DECISION DELEGATED TO DEVELOPMENT MANAGER

Application No: H08-1026-19 **Applicant:** Parochial Church Council c/o Deborah Reynolds

Proposal: Re-covering of Lady Chapel roof in terne-coated stainless steel

Location: The Church Of St. Peter & St. Paul Westhorpe Road Gosberton

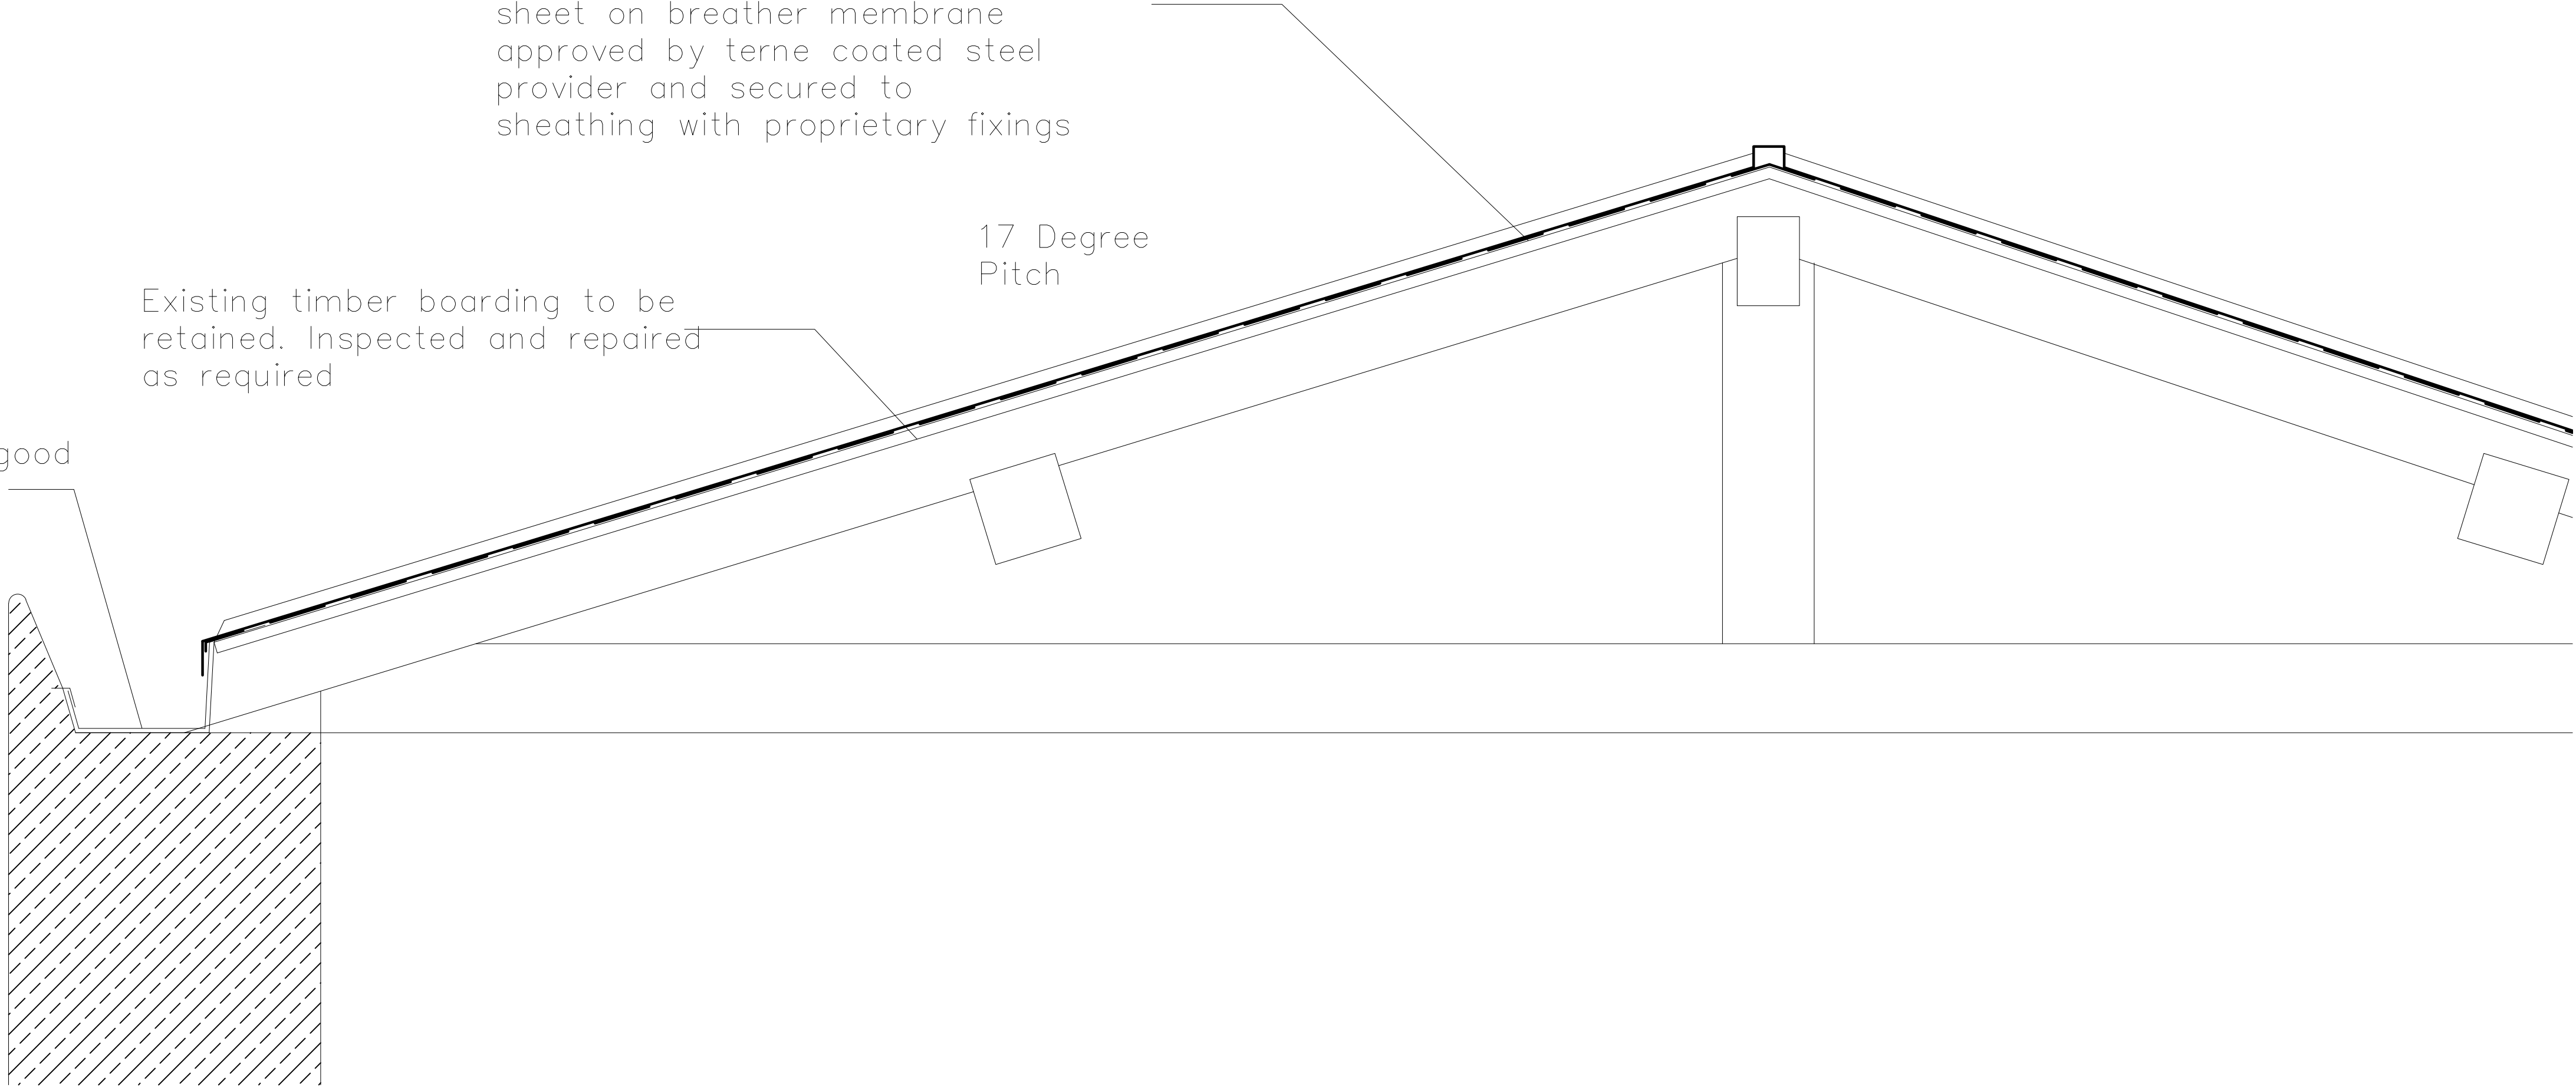
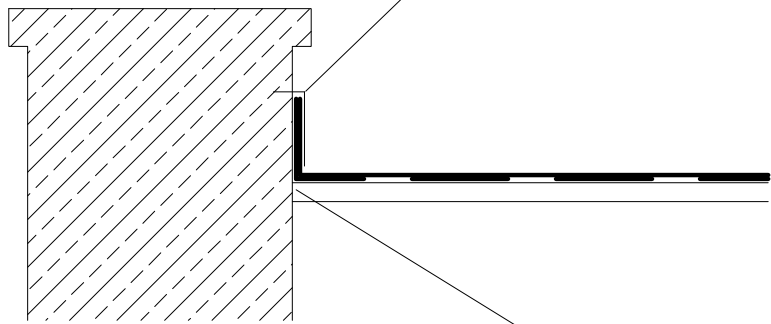
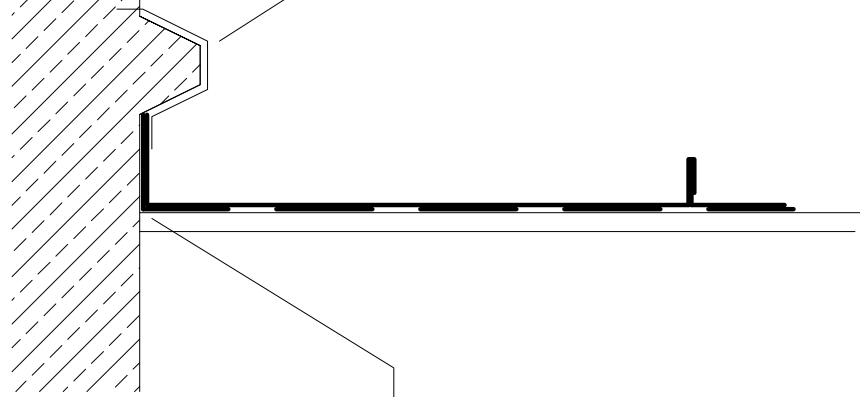
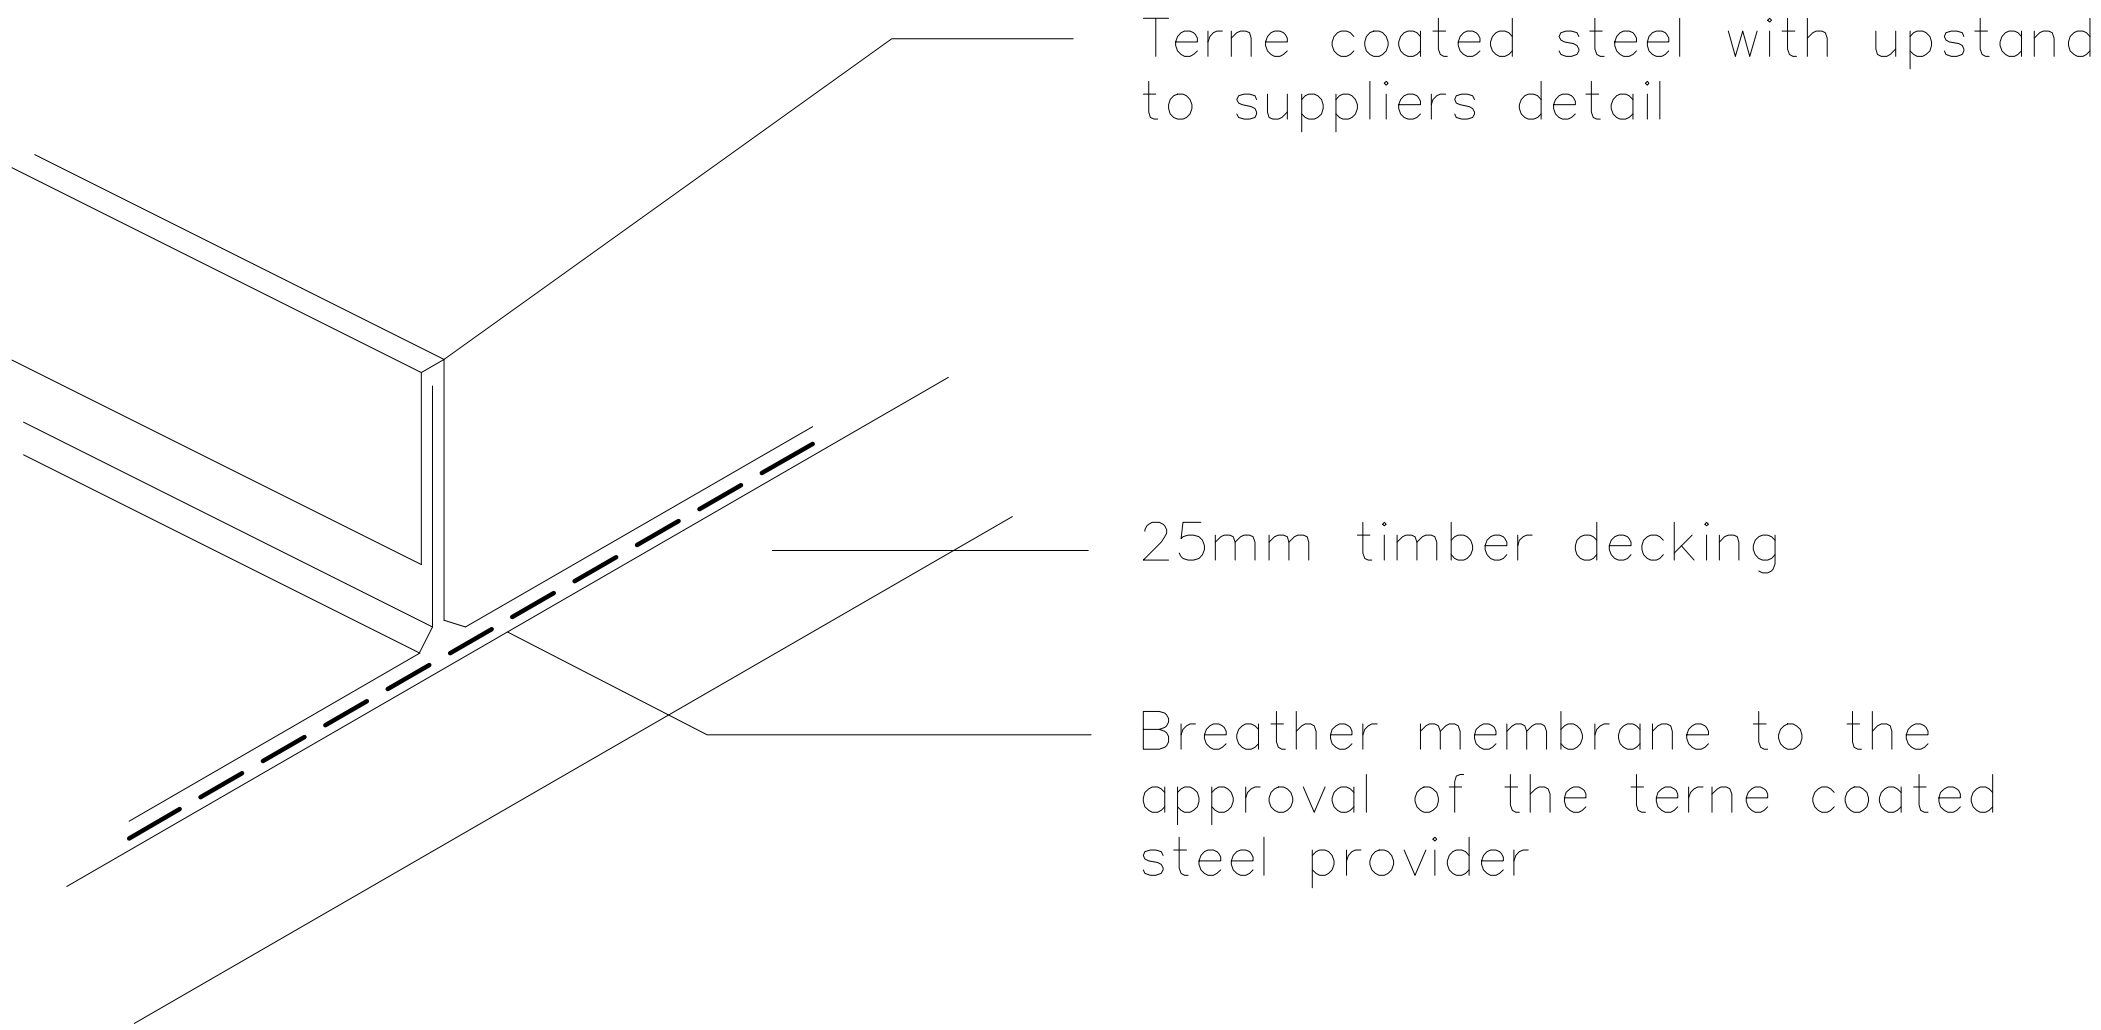
Historic England recommends round batten rolls as opposed to standing seams in such cases to preserve similarity of appearance and performance when compared with lead. The applicant has not specified which seam style is proposed.

Reinforcing this is the fact that following Historic England's suggestion that the seam type should be defined, the applicant has confirmed that timber rolls will be used, rather than the less preferable standing seam.
